# Planning Services Sign Permit Review Form

Date of Submittal	Application Number	Applicant	Landowner
Revised Plans submitted 5/19/2021	SIGN2105-0006	Commercial Permit Expediting, LLC	PTM LP

Contact Person	Contact Number	Sign Location	PIN Number
Jennifer Bardeschkeski	919-395-6959	2 signs located on NC HWY 87 N	9594-26-1847.000

PS1

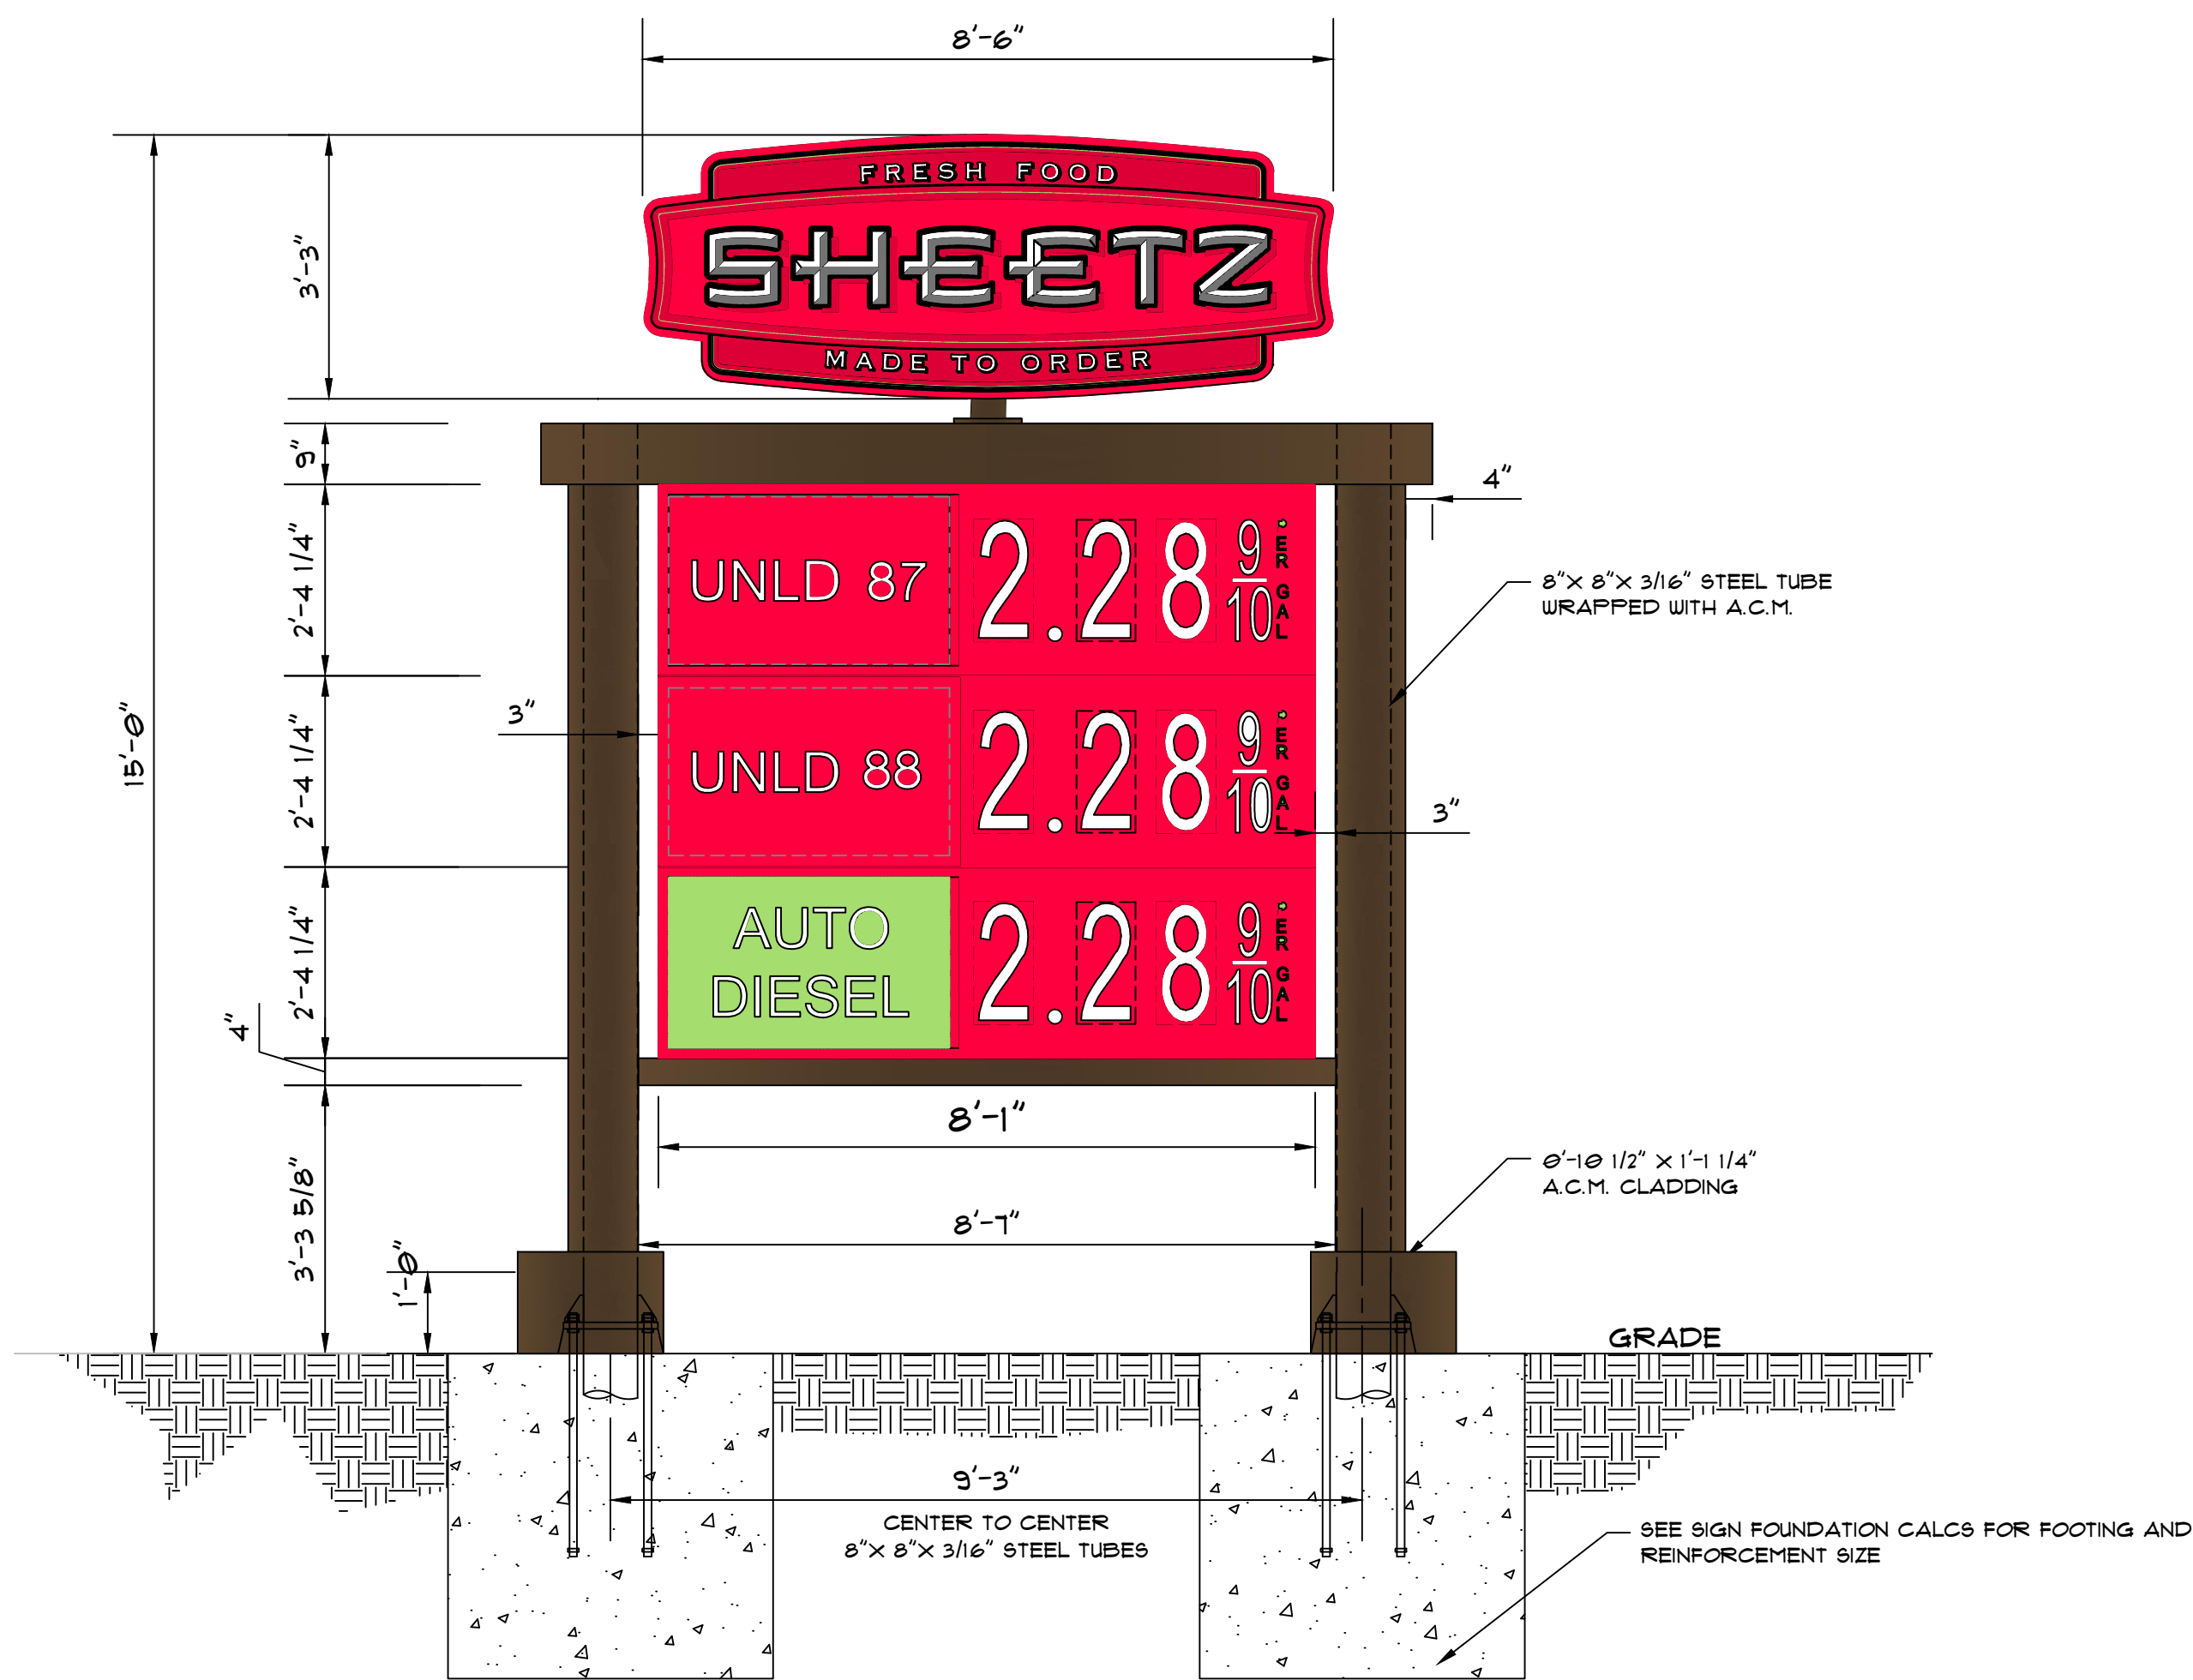
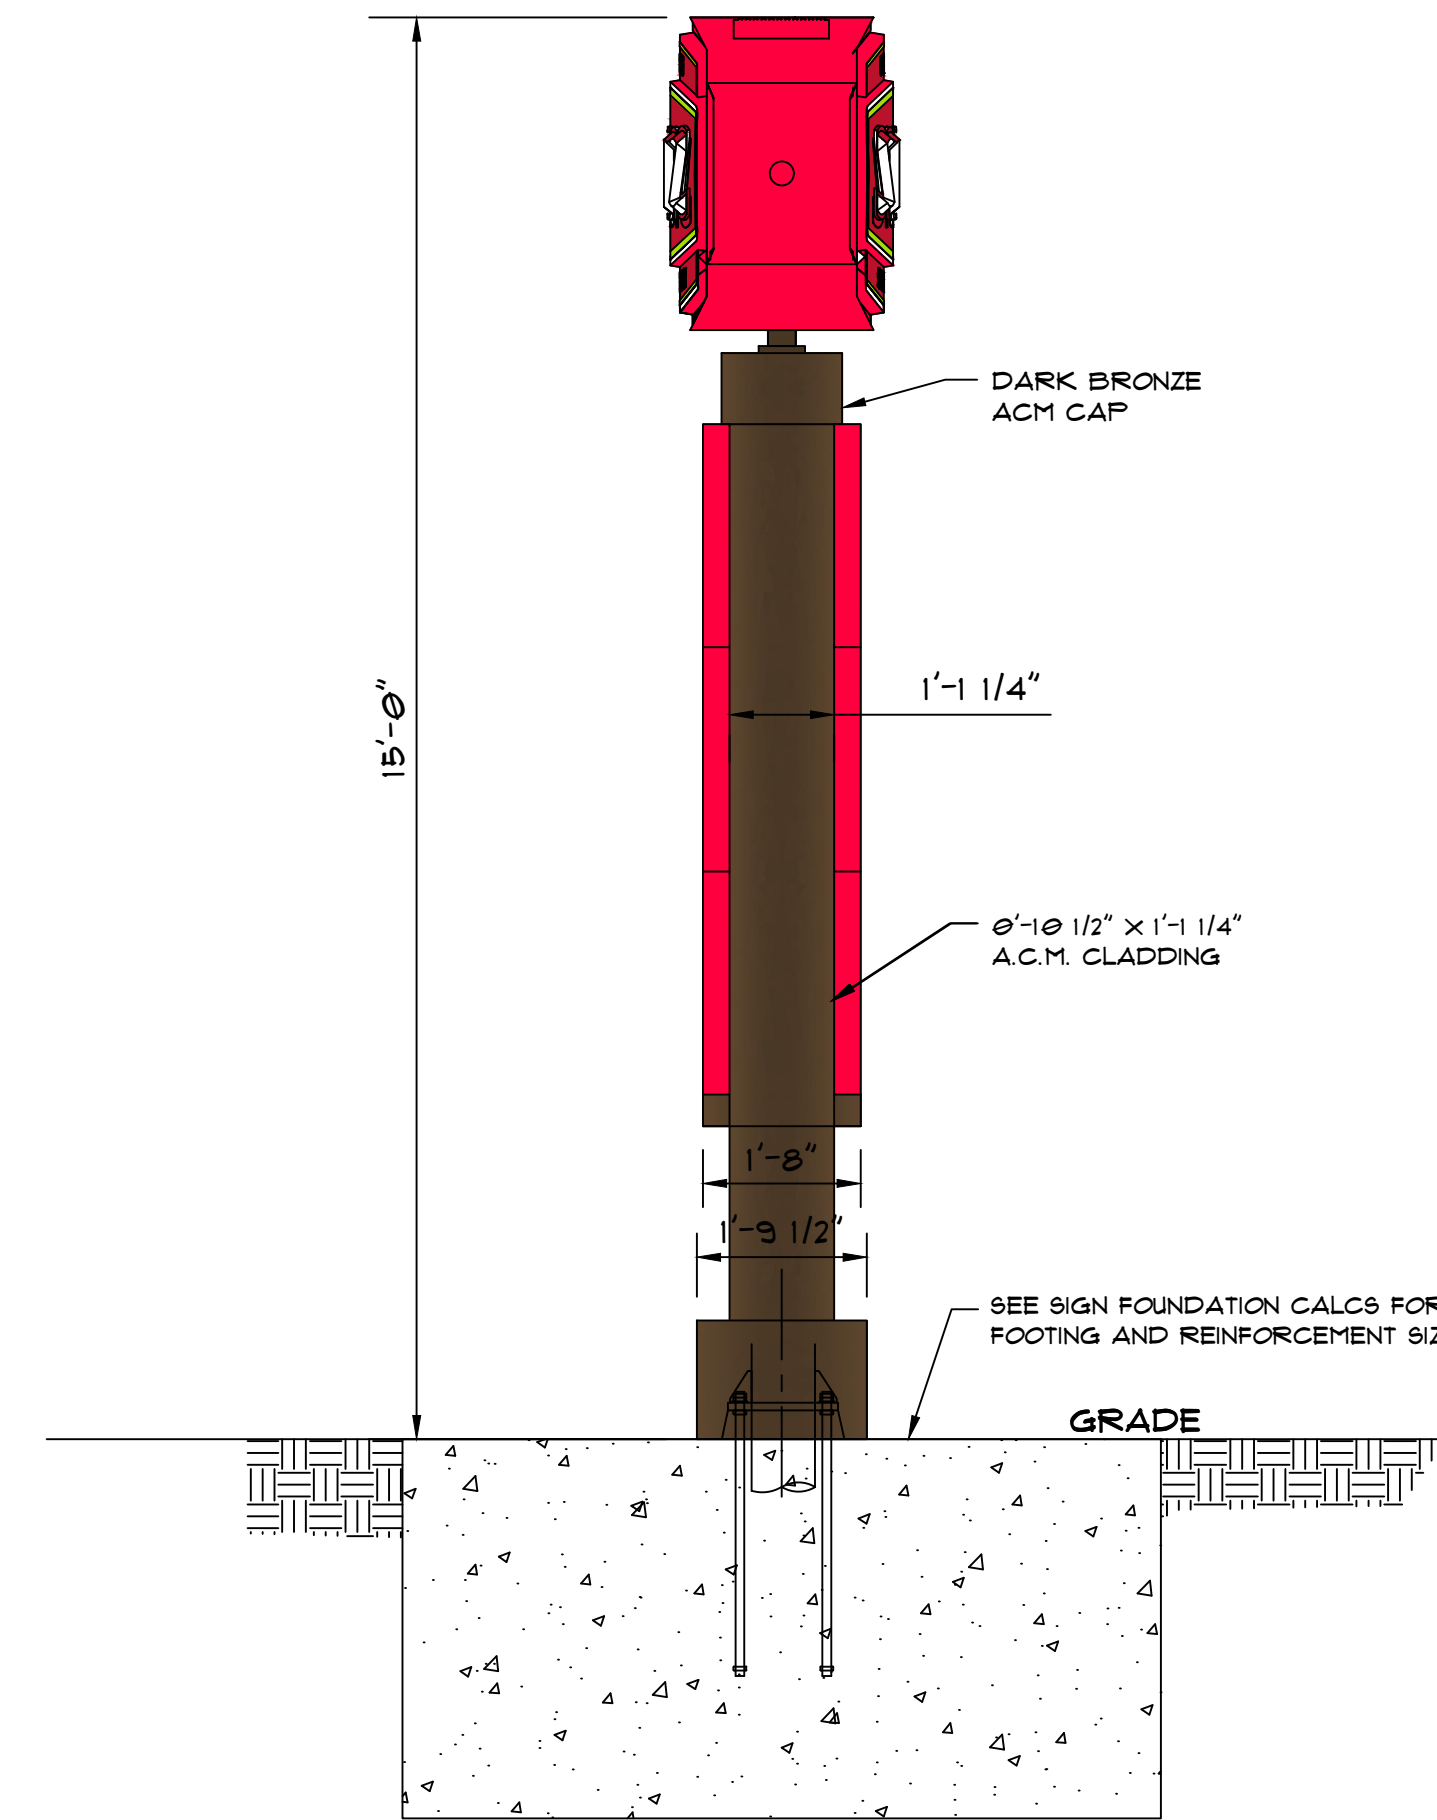
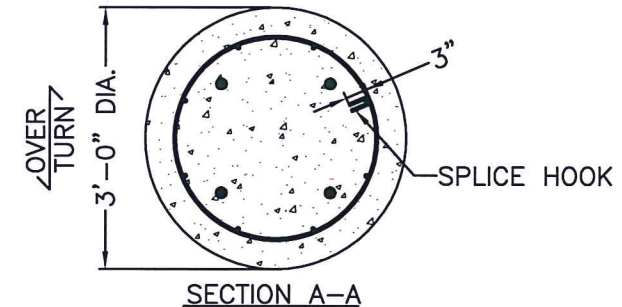
Comments	<p>Please see site plan, sign plan, and UDO code below.</p> <p><b>B. Said sign shall be constructed of an external support structure including stone, brick, ornamental metal or similar materials, provided that the maximum number of supports, uprights, bracings, or frameworks extending between grade and the base of the sign face shall not exceed two (2).</b></p>
----------	---
